18 May 2020

Re. Cherwell District Council Planning Application 19/01740/HYBRID

The Albion Land's Design for New Roundabout at Catalyst Development, Bicester [10/01740/HYBRID] does not reflect these principles, and will not deliver adequate improvements for walking and cycling which are consistent with the stated design standards. Specifically the plans outline:

JOB TITLE CATALYST BICESTER		CLIENT ALBION LAND	
DRAWING TITLE WENDLEBURY ROAD SITE ACCESS ROUNDABOUT			
SCALE 1: 500@A1	DRAWN BY RJM	DATE 03/05/19	DRAWING No 19539-12-02
REVISION B

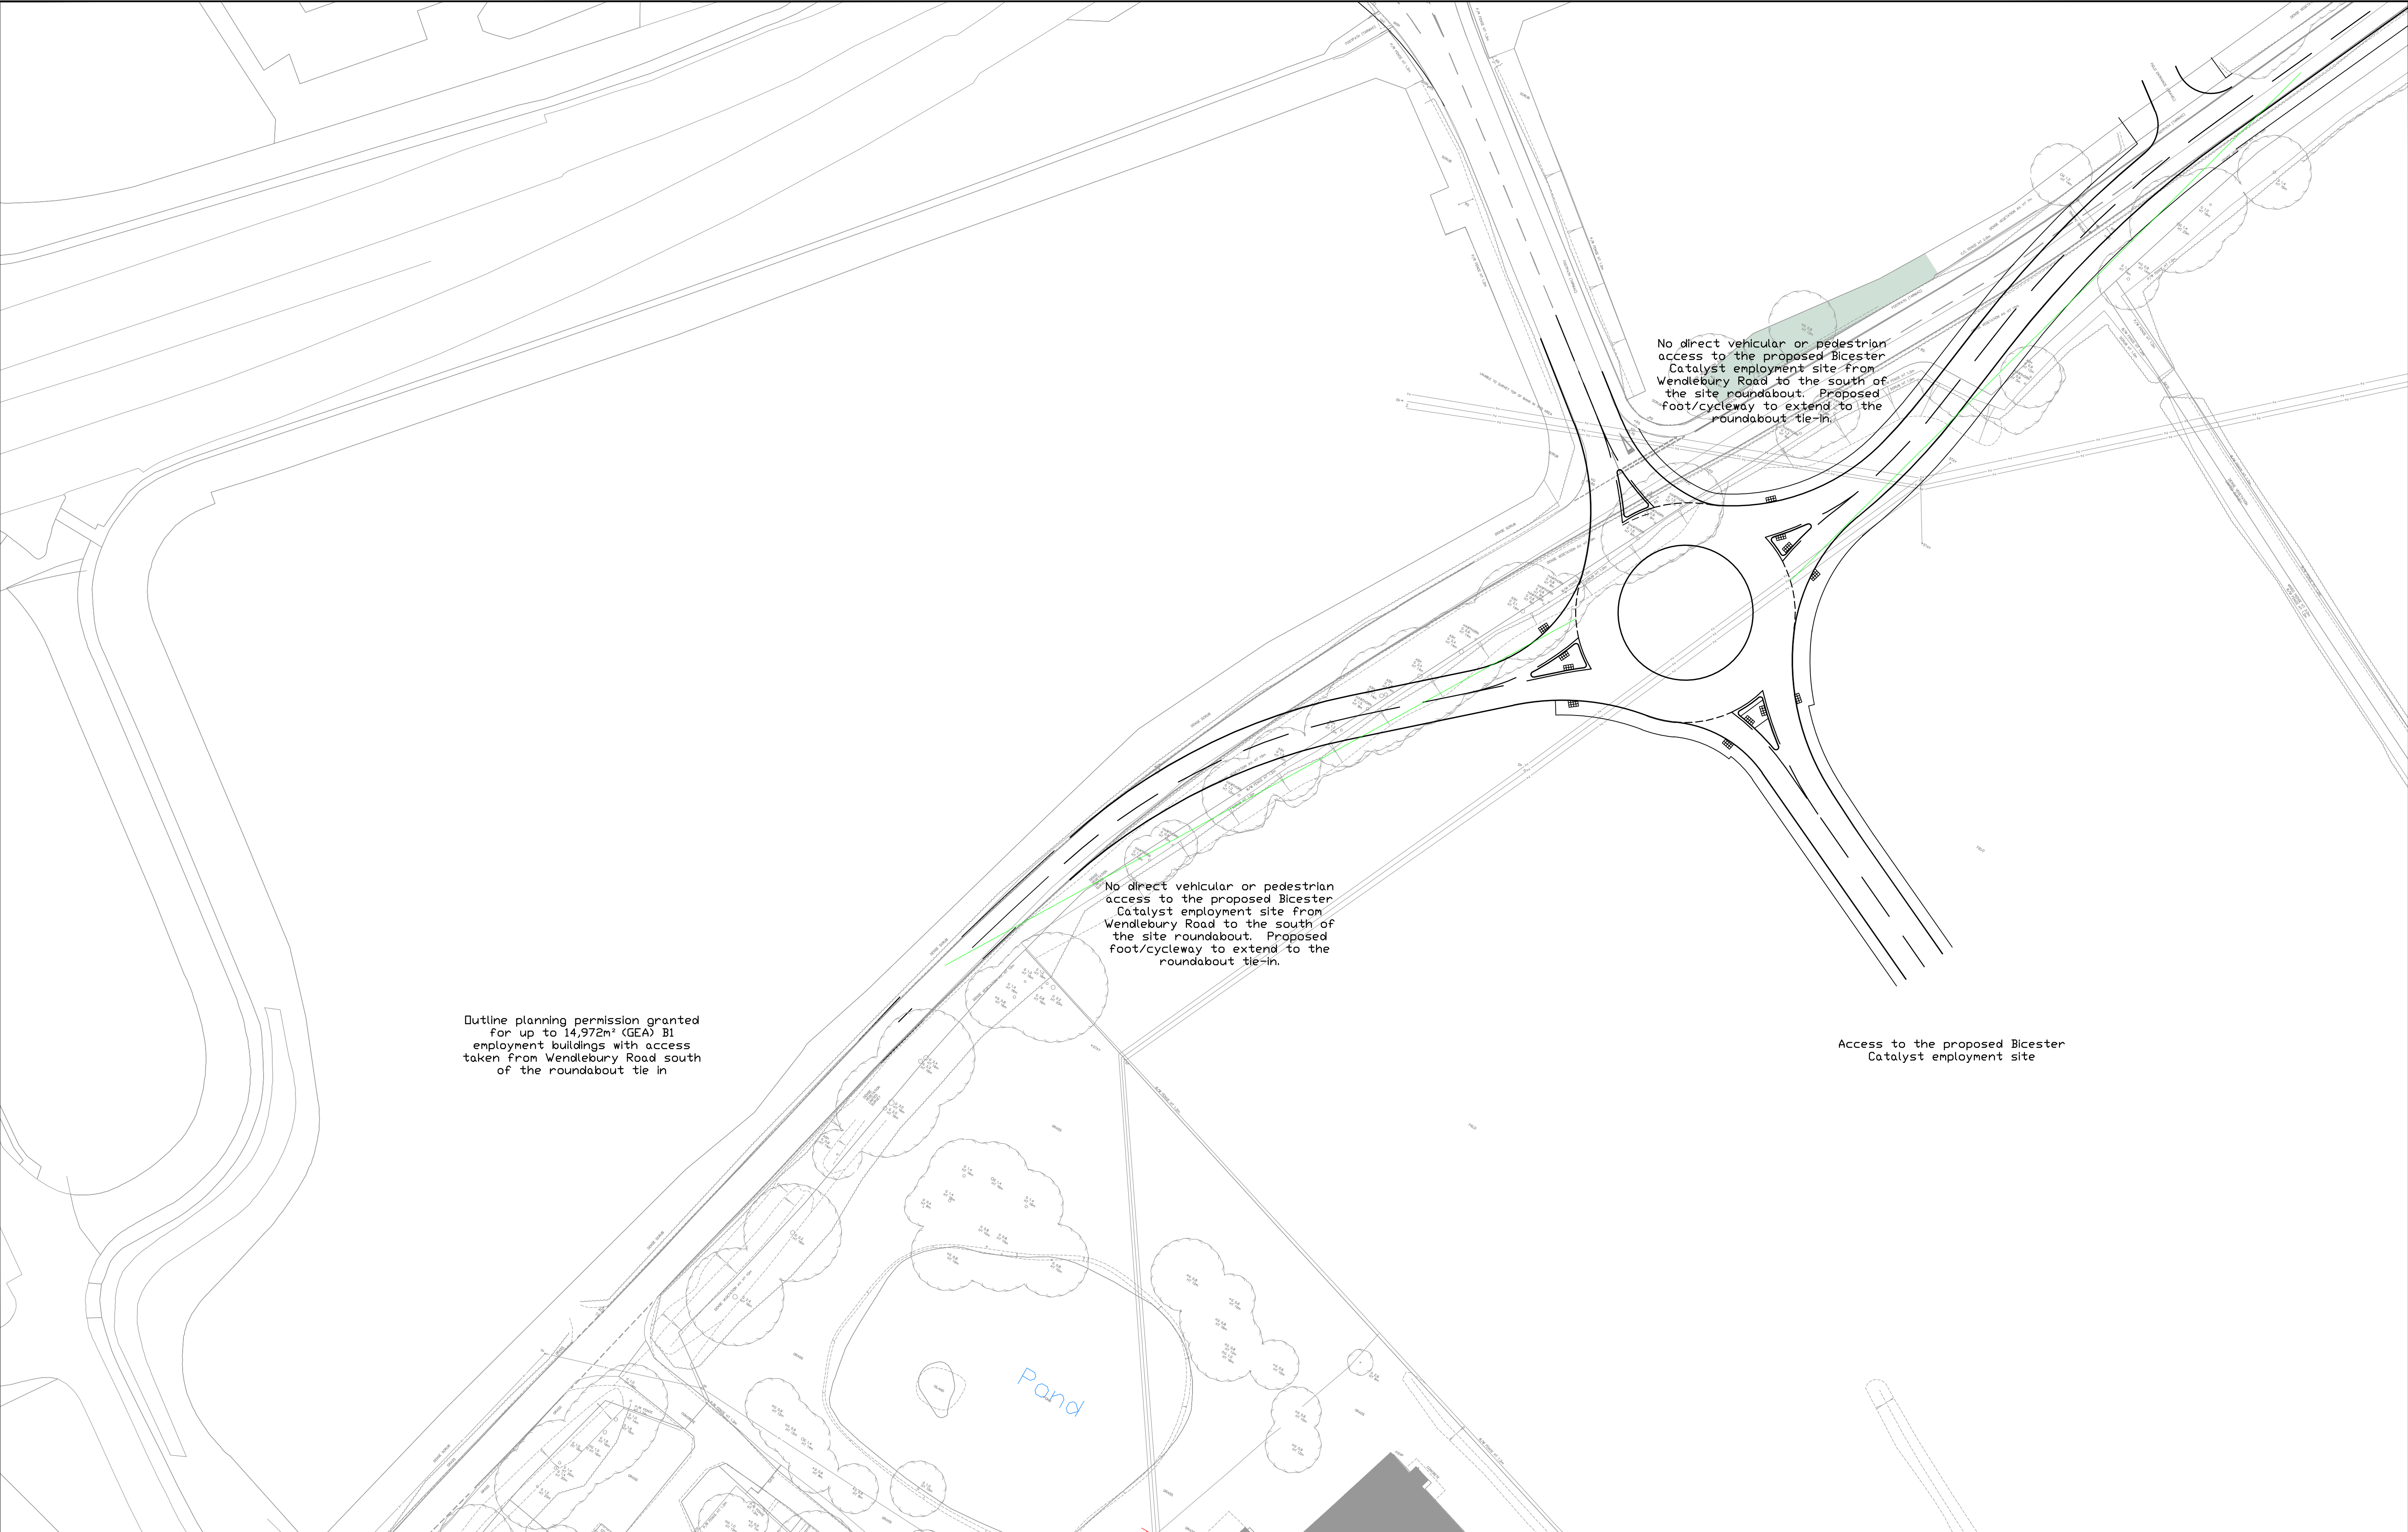
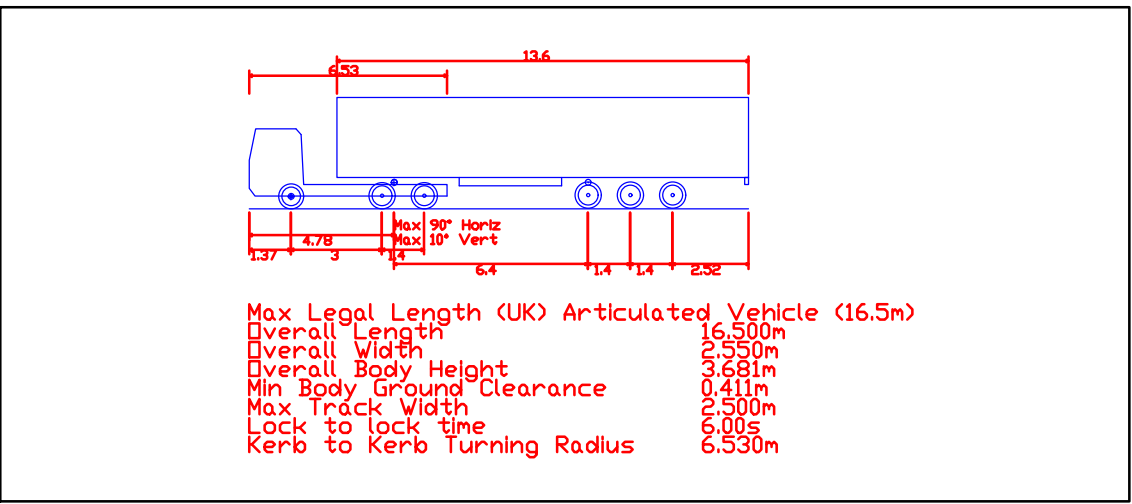
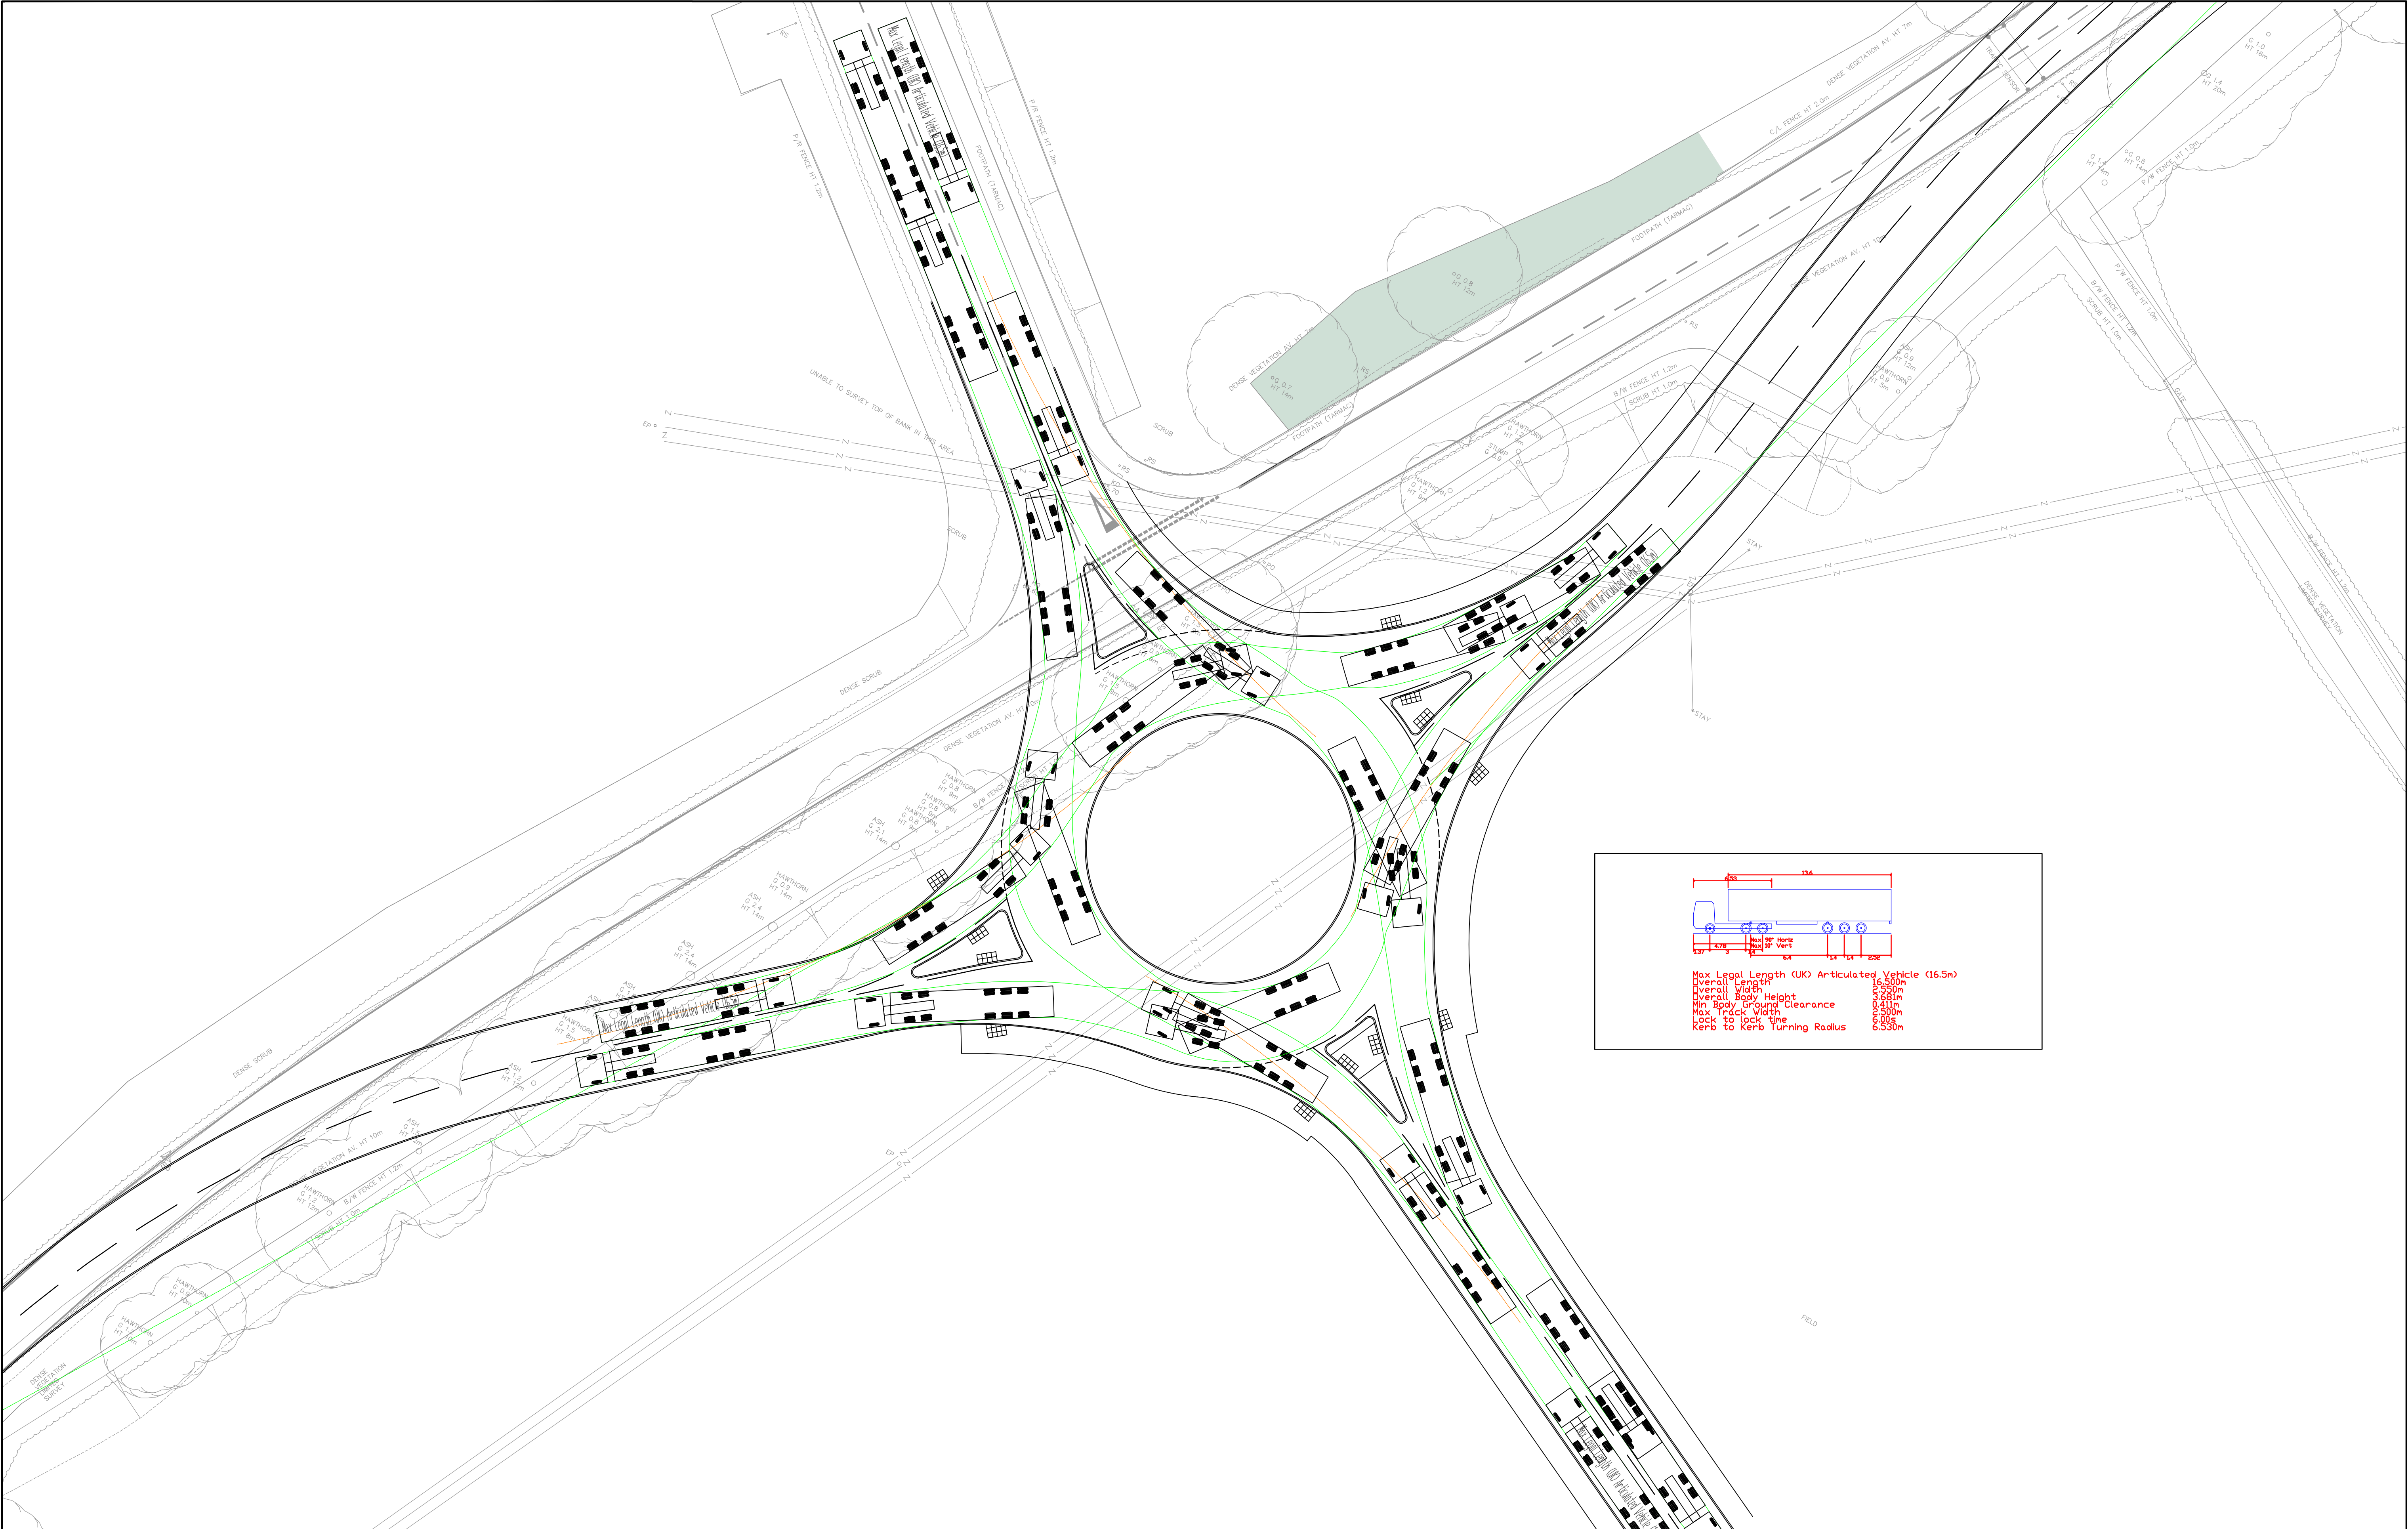
1. Provision for pedestrians only in many areas
2. A confusing design with multiple junction types
3. No horizontal separation between carriageway and paths
4. No waiting areas meaning that pedestrians and cyclists waiting to cross carriageway will block the paths.
5. No transitions between the shared paths and carriageway

In my role as **County Council Cycling Champion**, I have observed some excellent progress with regard to co-design for key infrastructure to achieve improvements for active travel. I very much hope this opportunity will be used to revisit this design with the support of Bicester Bike User Group and other local users, focusing upon the needs of vulnerable road users at this location.
